Objection to the East Pye Solar Development Consent Order

Personal impact on our home, our family and Footpath 6, Brooke (Site 9)

Project	East Pye Solar (Planning Inspectorate reference EN0110014)
Applicant	East Pye Solar Limited (Island Green Power)
Submitted jointly by	Michael Phillips and Helen Phillips
Address	[REDACTED]
Interested Party reference	[REDACTED]
Submission	Joint Written Representation for the Examination deadline of 6 October 2026
Date	5 October 2026

FIGURE 10.3
INDICATIVE ROUTEING AND ACCESS

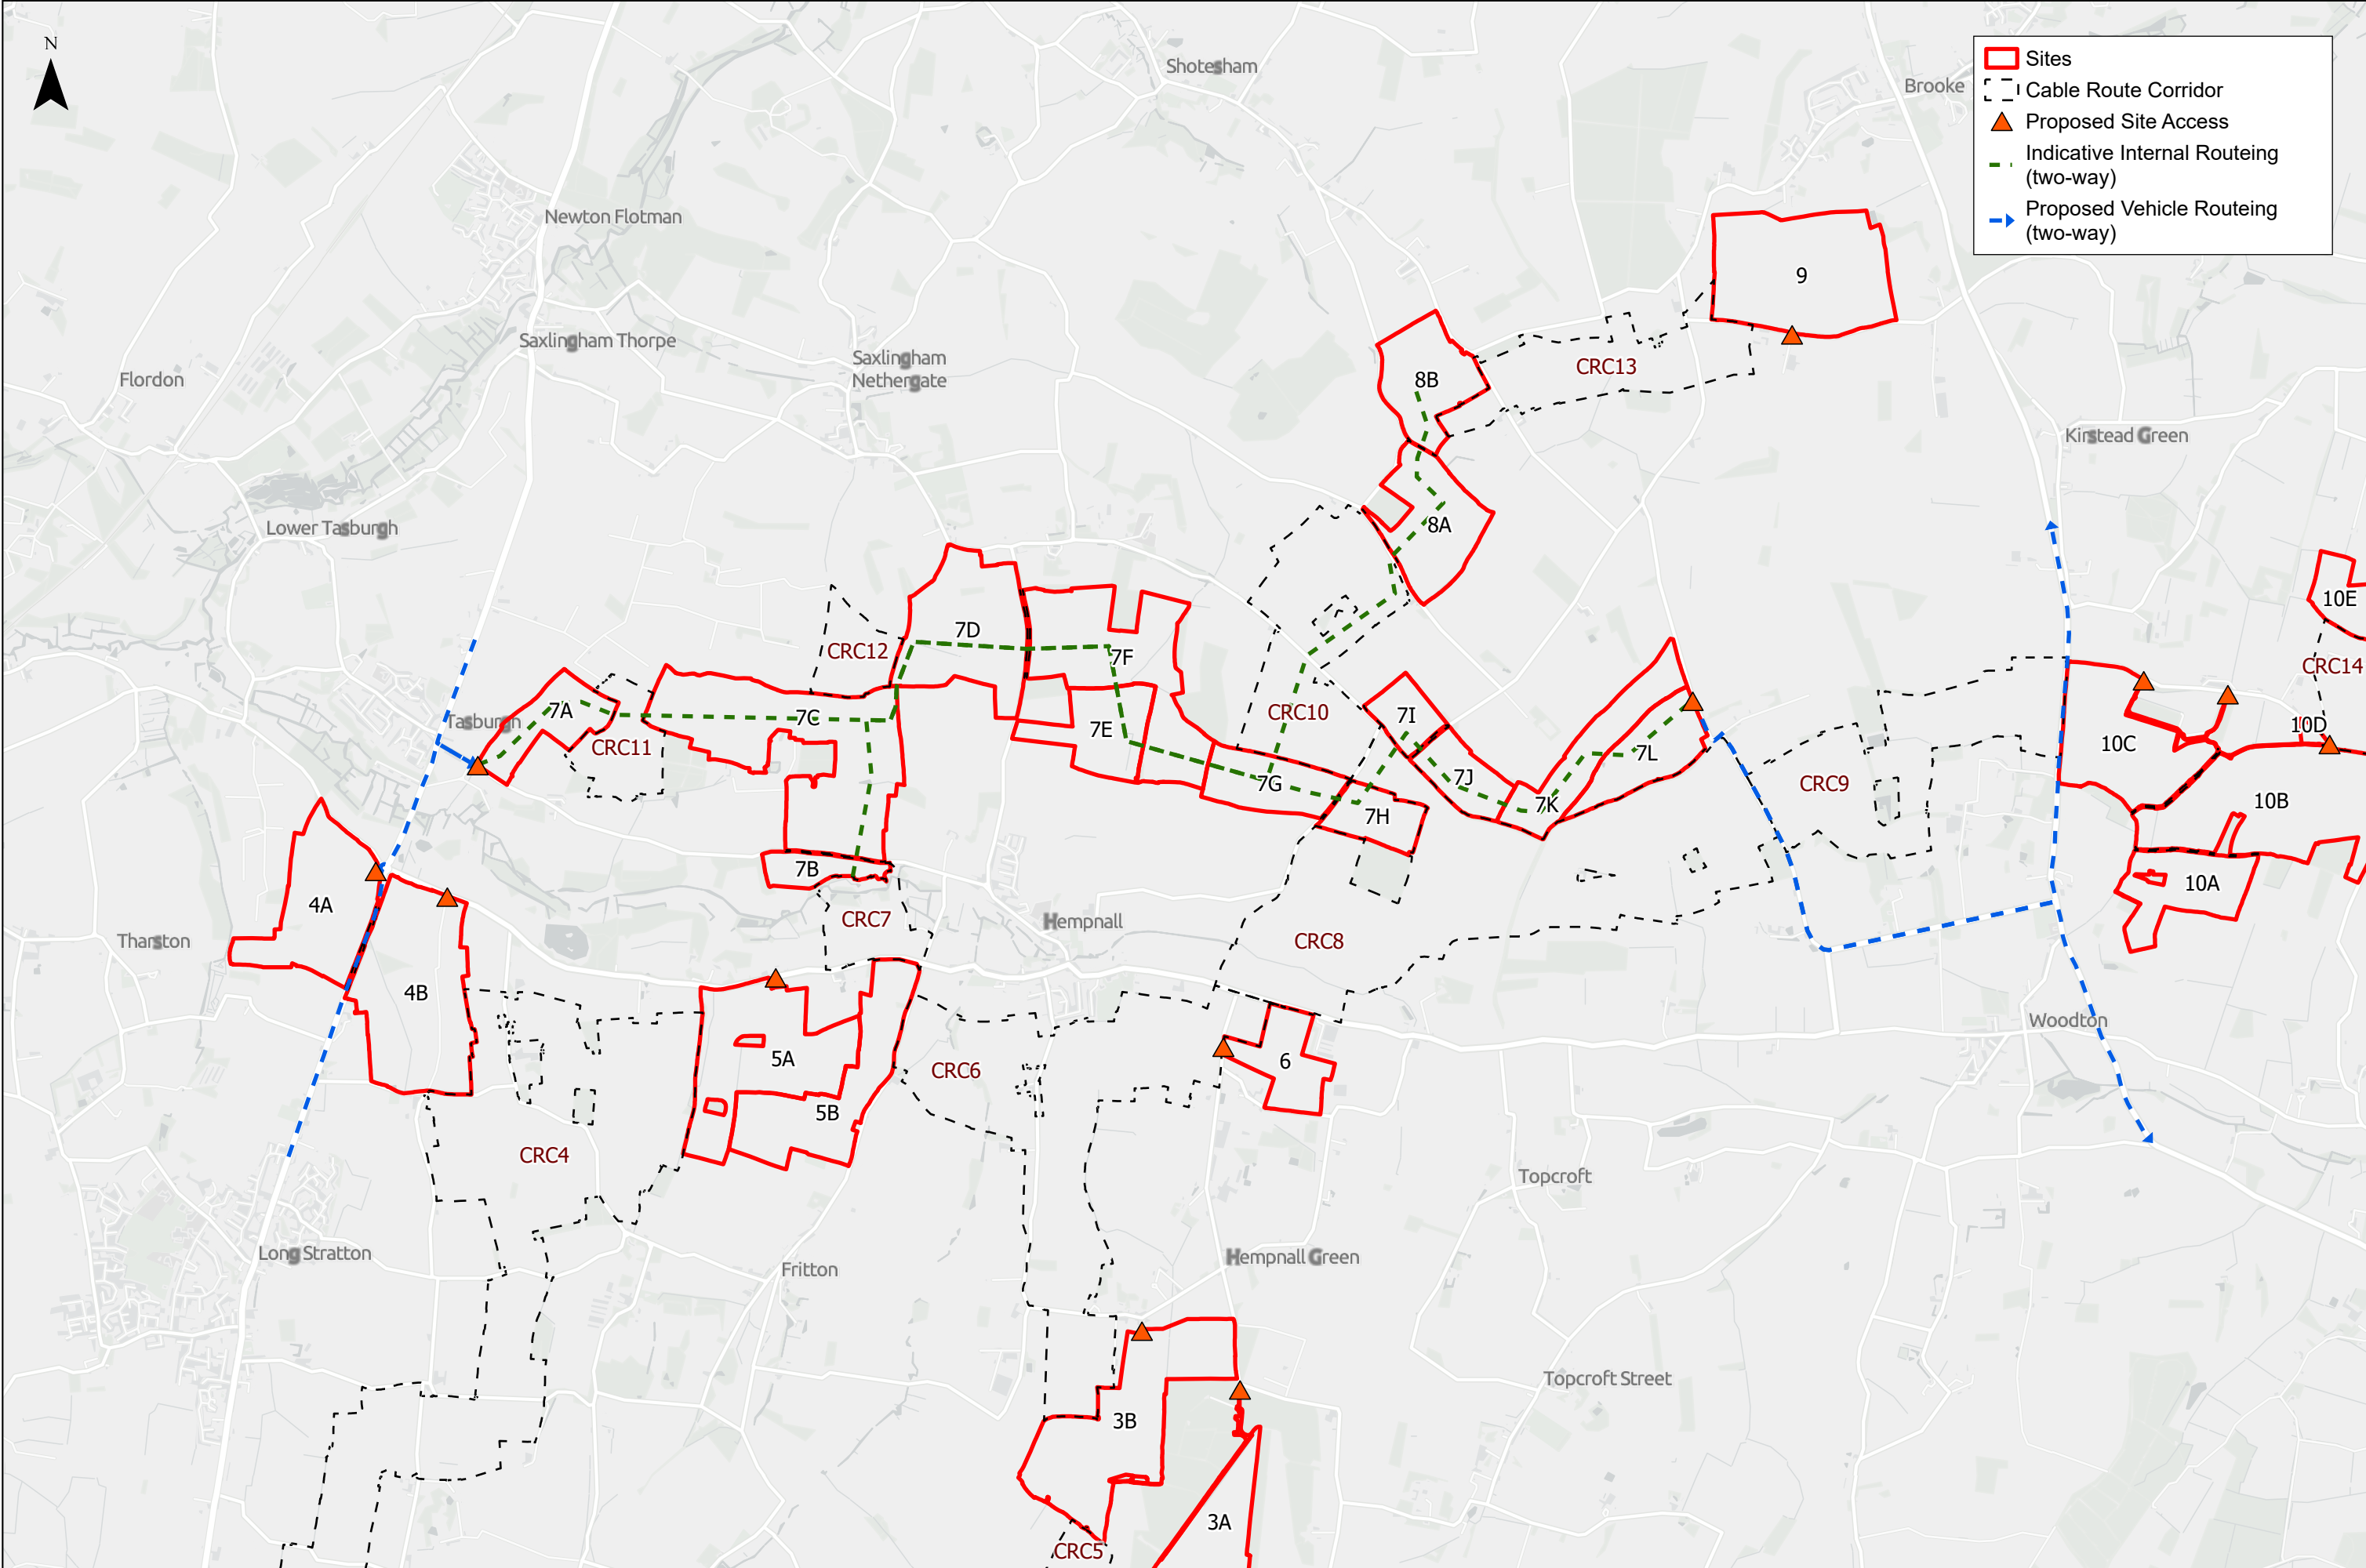
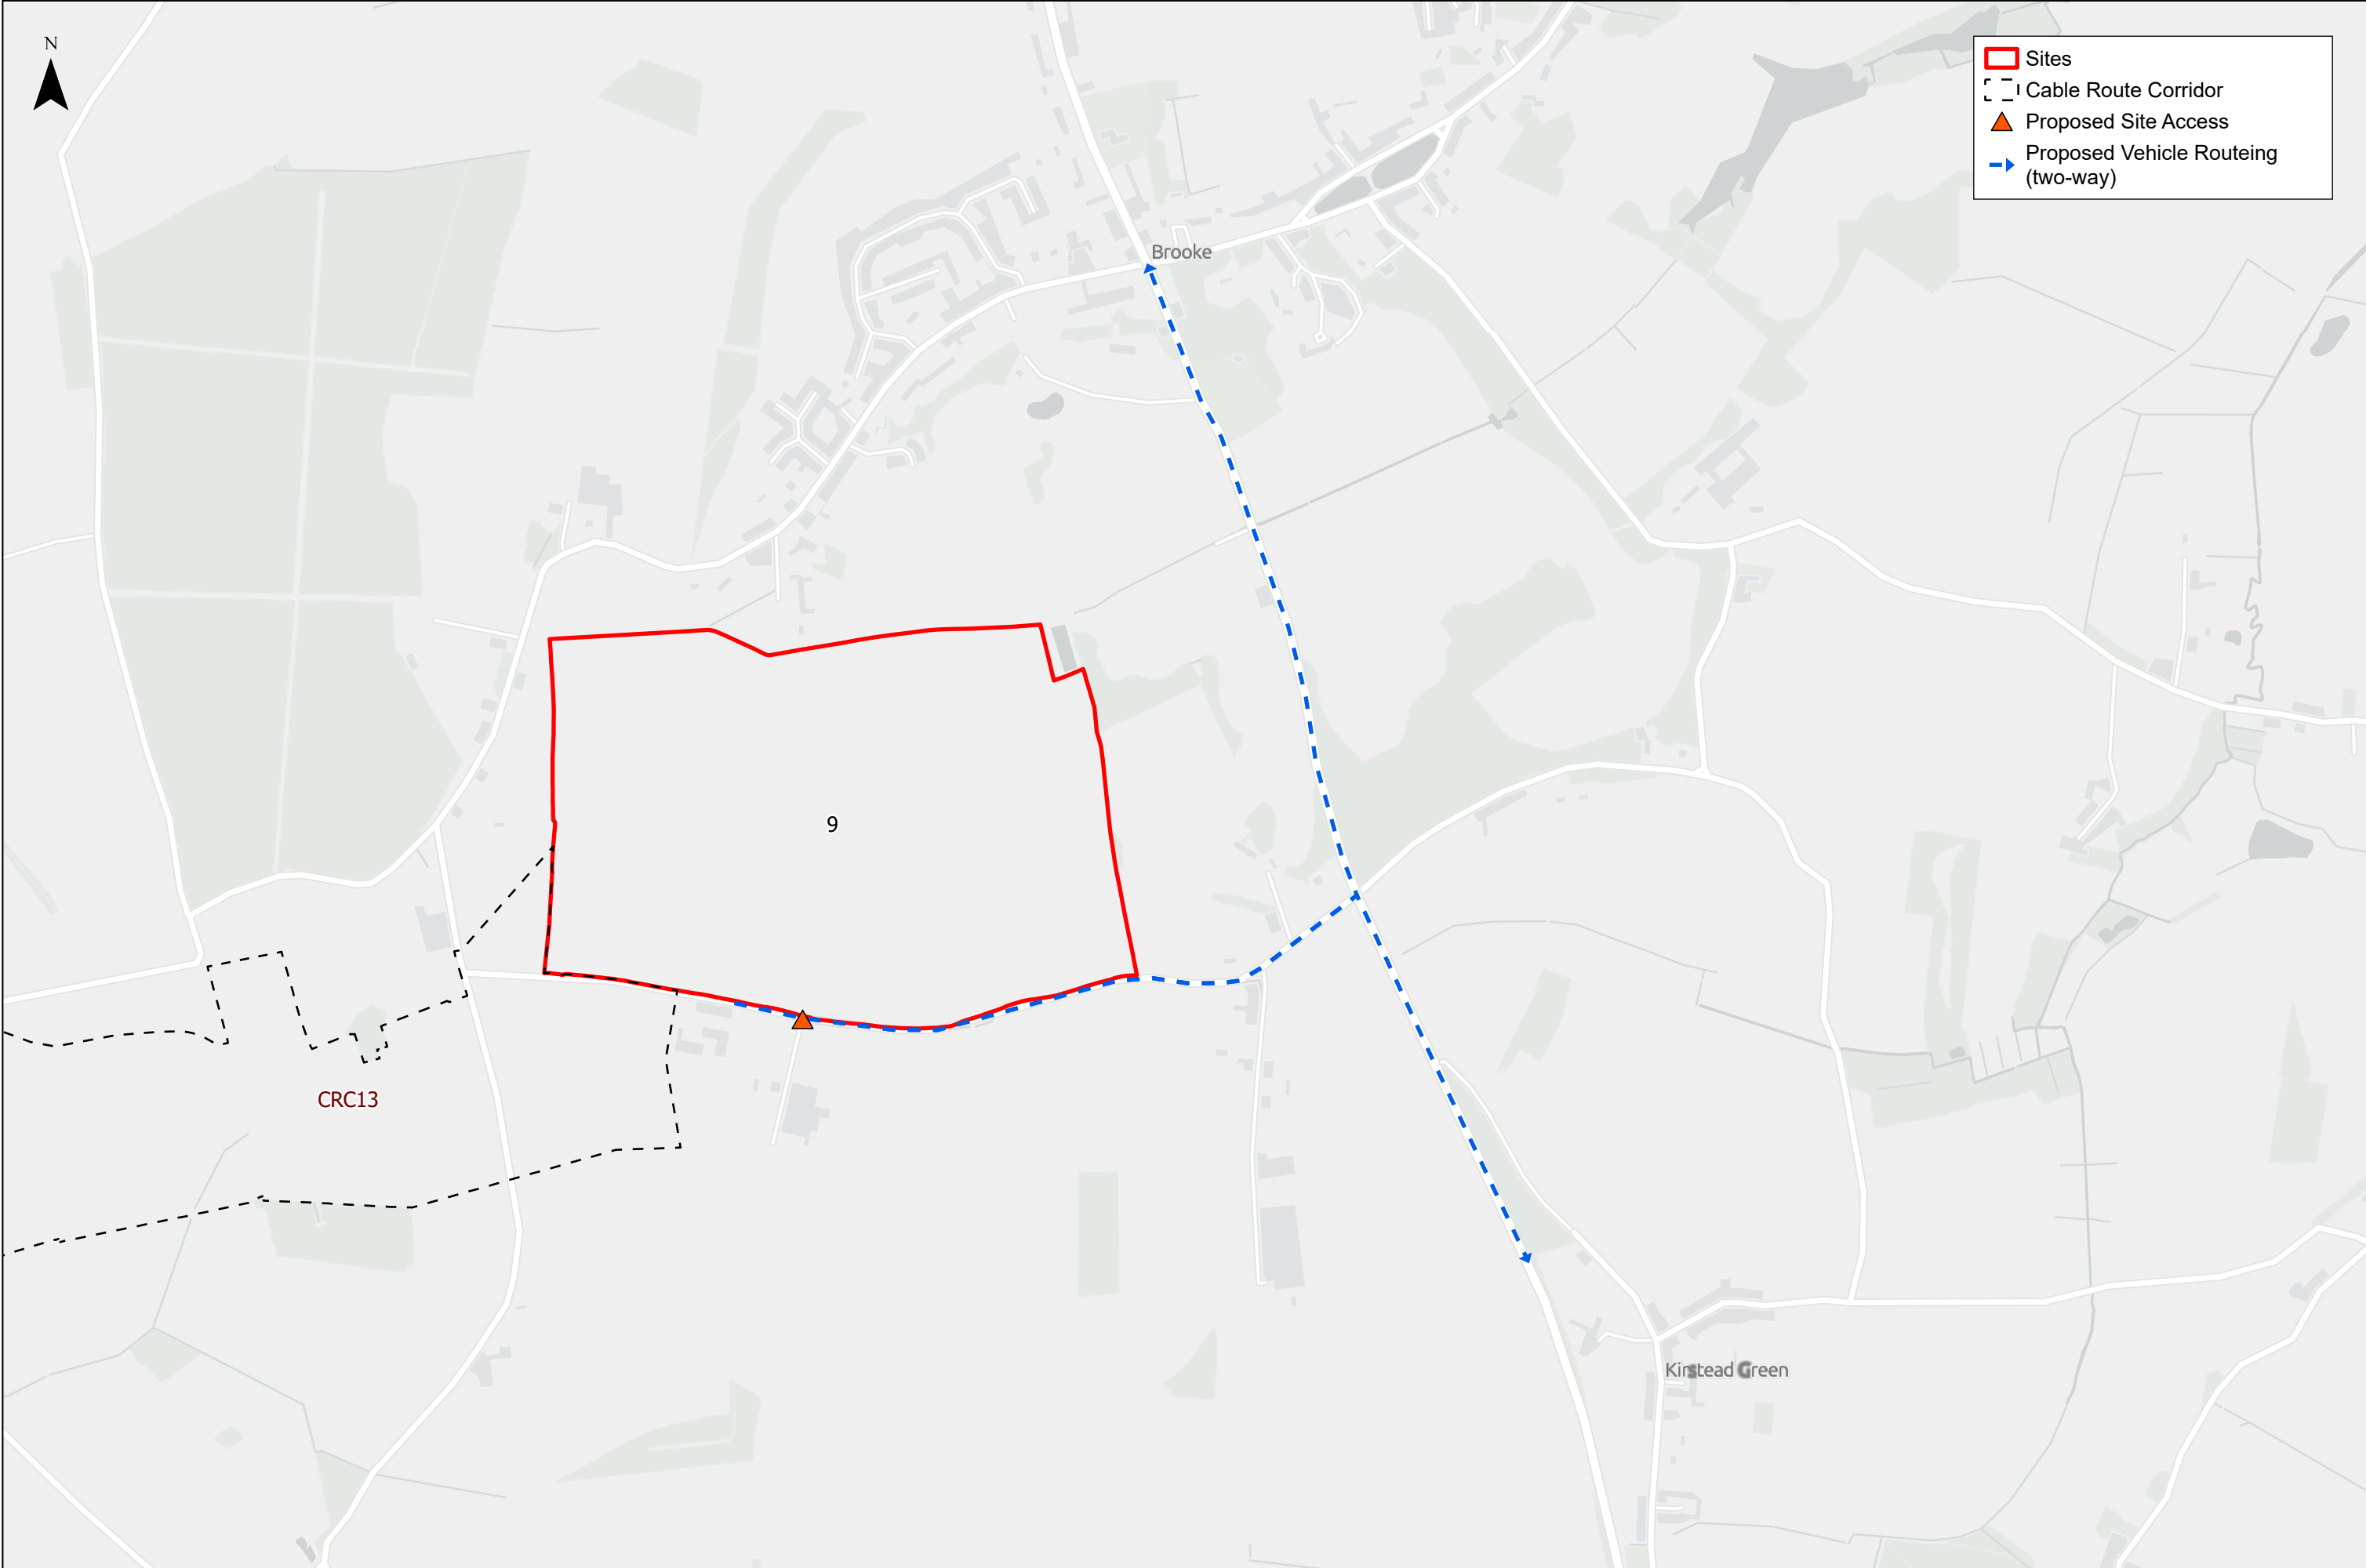
Despite this, the applicant identifies Littlebeck Lane as an access route for Site 9. Option A in the Scoping Report is "From B1332 Norwich Road, westbound on Littlebeck Lane, north onto access point on Site 9" (Table 10.4). The applicant's published figures show:
